**TO:** Jeff Watson, CDS  
**FROM:** Christina Wollman, Planner II *CW*  
**DATE:** October 29, 2013  
**SUBJECT:** Hundley SG-08-00032

Kittitas County Public Works has reviewed the final submission for the Hundley SG08-00032. In regards to the property within Section 25 T20N R 14E, the final design differs from the previous design in that the private road travels through the private property to Lots 1, 2 and 3 instead of along Chepoda Road. A 60' easement has been recorded (201307300010).

PART OF SECTIONS 25 & 26 TOWNSHIP 20 NORTH, RANGE 14 EAST, W.M.

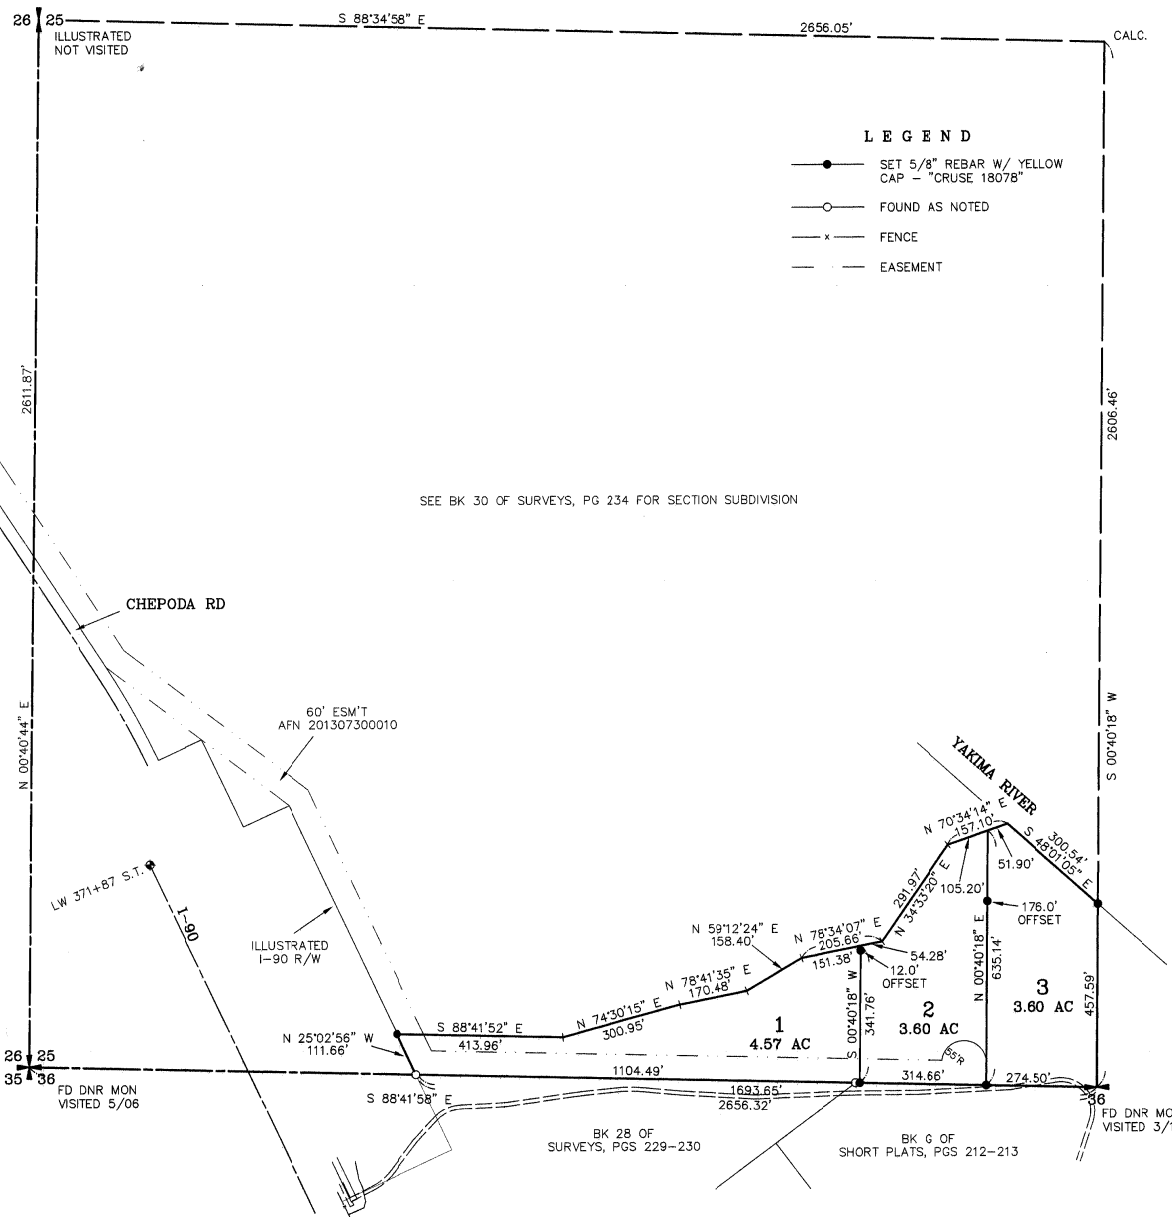
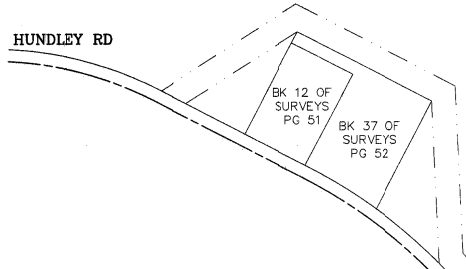
Review of the property indicates that most of the 60' easement is within a conservation easement granted to Washington Department of Fish and Wildlife in 2010. The easement removed all development rights from the property, but allows a maximum 15' wide road along the southwesterly edge of the property (201011240020, Section IV, D).

Kittitas County Road Standards will require the roadway to be constructed to 22' in width. Based on the information available within the conservation easement document, this road width is not allowed.

Prior to final approval of the BLA, Public Works will require documentation of approval from WDFW for the landowner to construct a 22' wide road within a 60' access easement in the area encumbered by the conservation easement. This road is required to be constructed prior to issuance of a building permit.
